Development Facilitation Team (DFT) – Review Comments

Project No: PR-2023-009609

Application For: SD-2024-00025 – PRELIMINARY/FINAL PLAT

Project Name: Lots 14-A & 15-A, Highland Place Addition

**PLAT OF LOTS 14-A & 15-A  
HIGHLAND PLACE ADDITION**

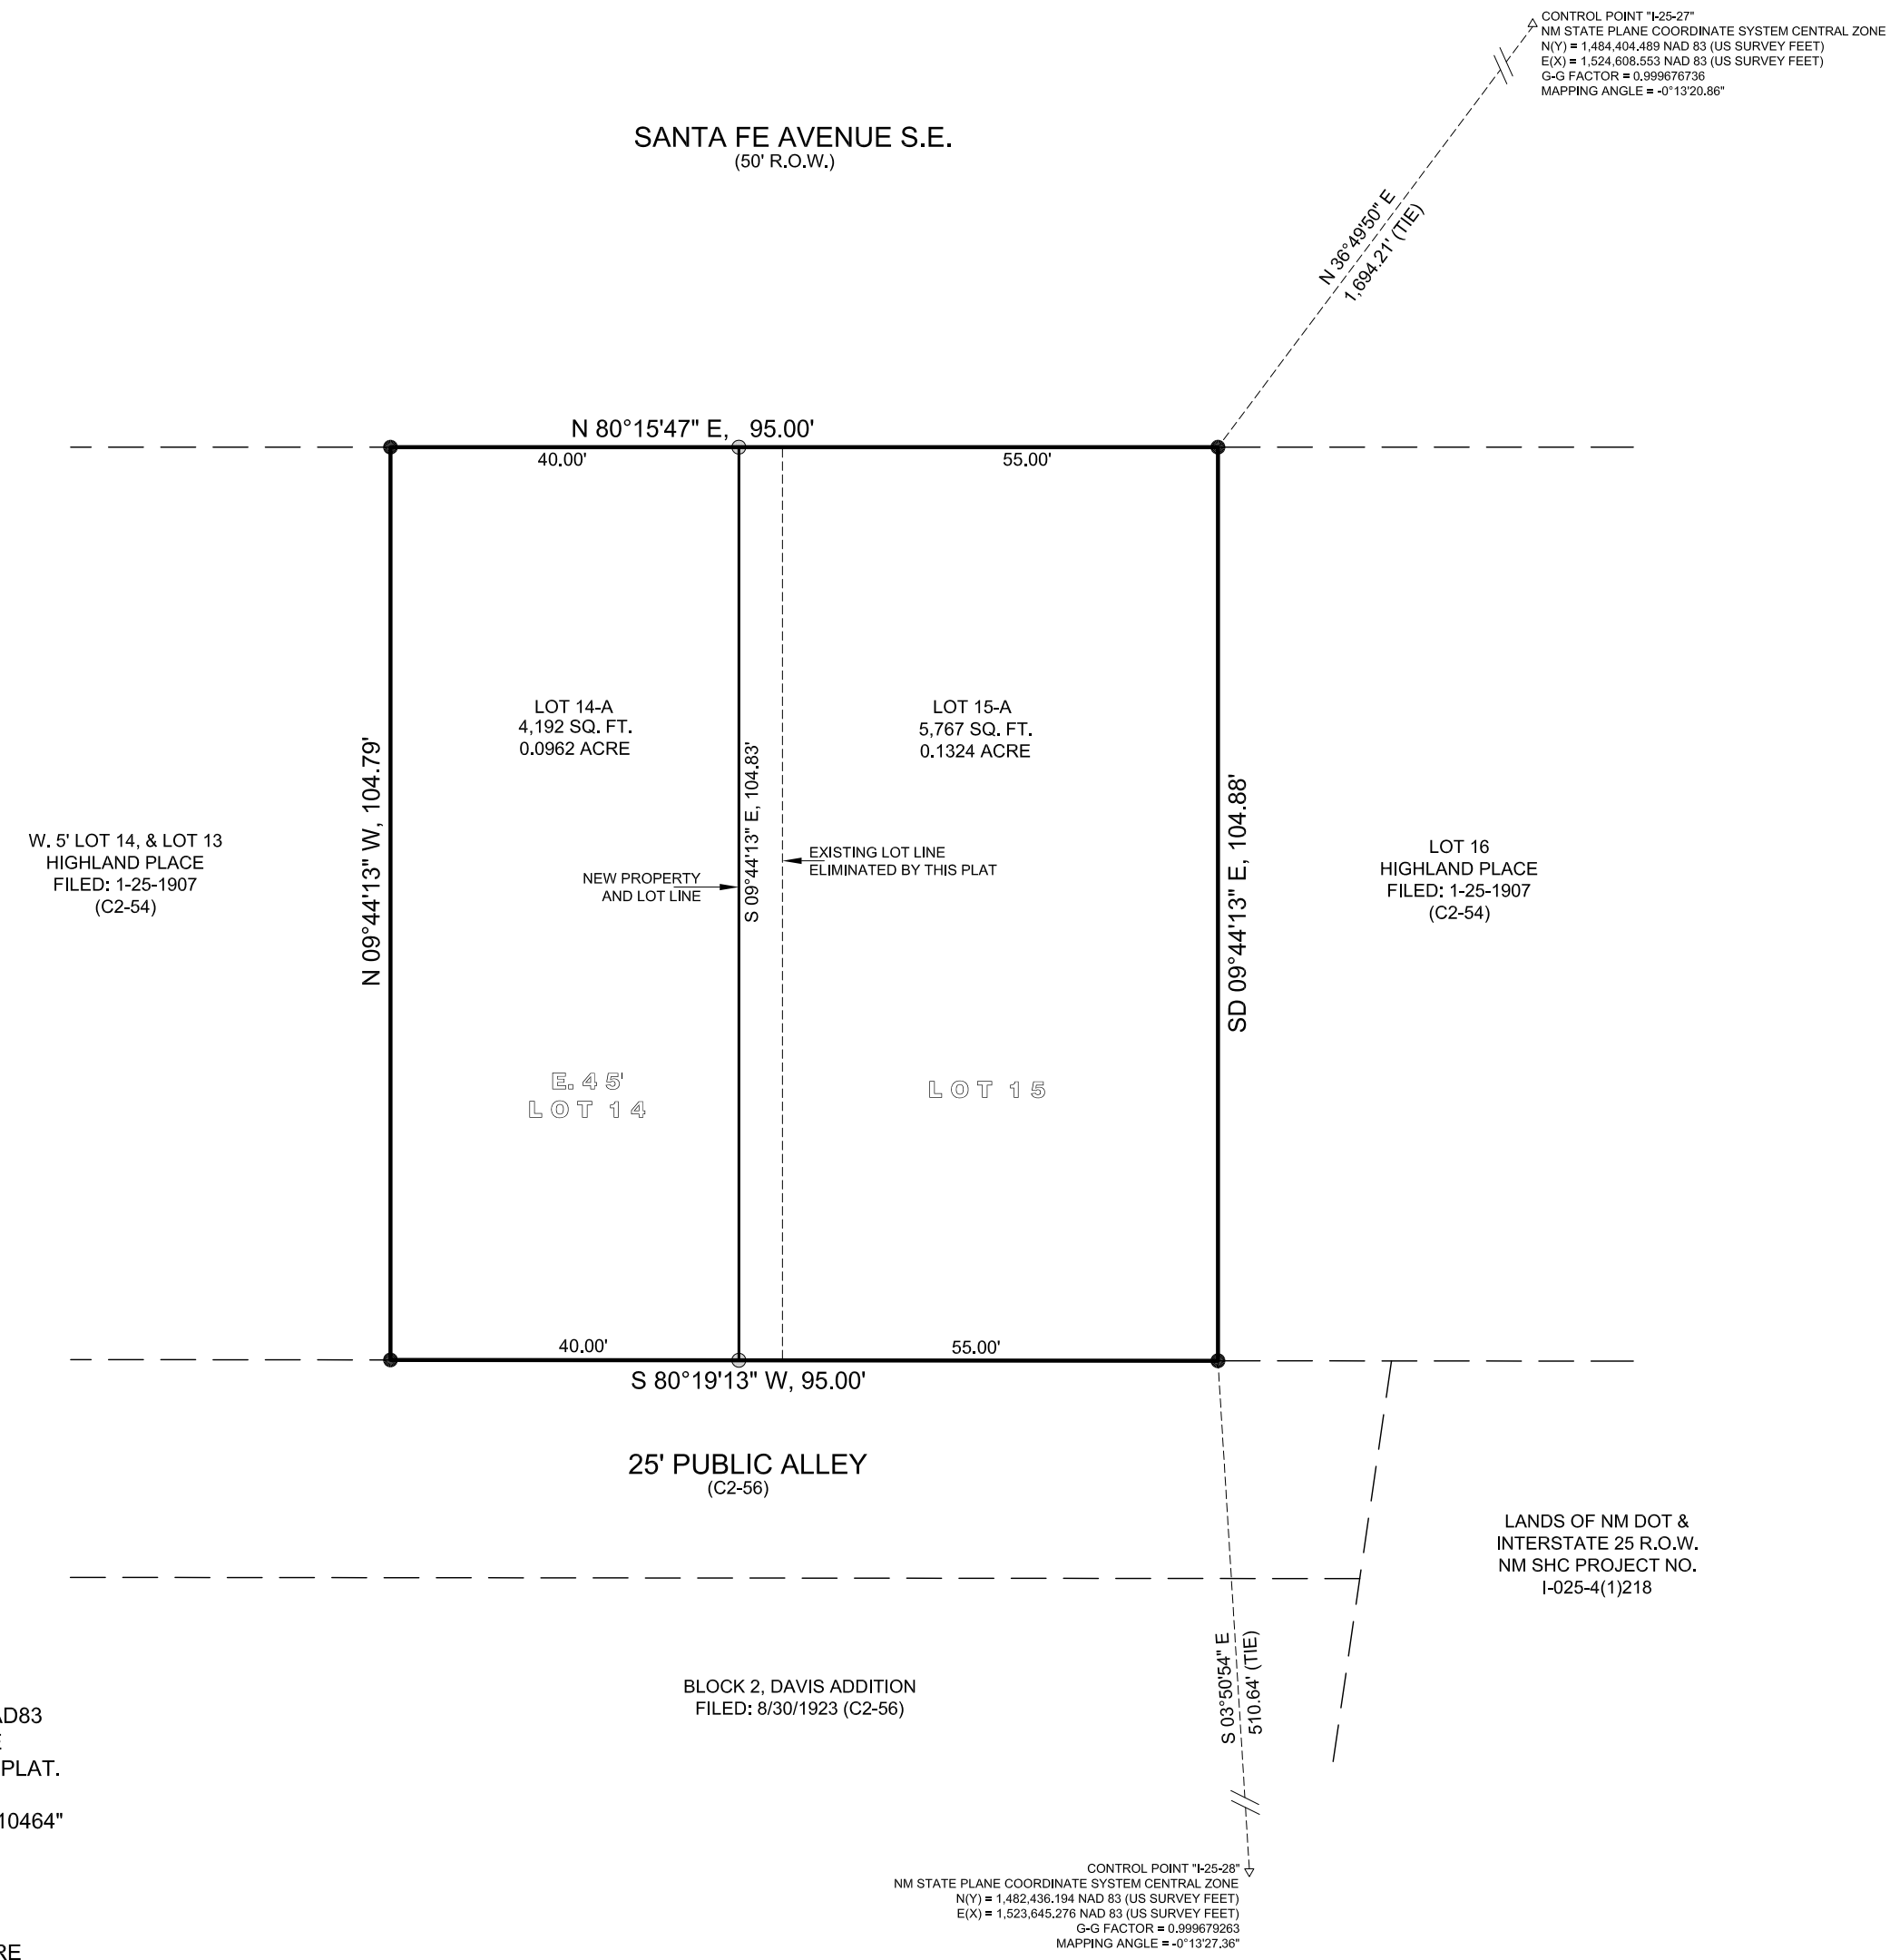
- According to property records as well as the application, Jamie & Agnes Perez, C/O GHI, Inc. owns the subject property. However, the Plat is signed by David Garcia as the owner. Proof of signatory authority must be provided that David Garcia can sign the Plat as the owner.
 - The AGIS office must approve the DXF file and proof of approval must be provided prior to final sign-off of the Plat.
 - ~~The application number must be added to the Plat.~~
 - Per 6-6(L)(2)(d)(7) of the IDO, the date of the DHO approval shall be recorded on the Plat. Therefore, prior to final sign-off of the Plat, the date of the DHO approval must be added to the Plat.
 - After DHO approval and final sign off, a recorded copy of the plat must be sent to Angela Gomez at agomez@cabq.gov and to Jay Rodenbeck at jrodenbeck@cabq.gov.
-
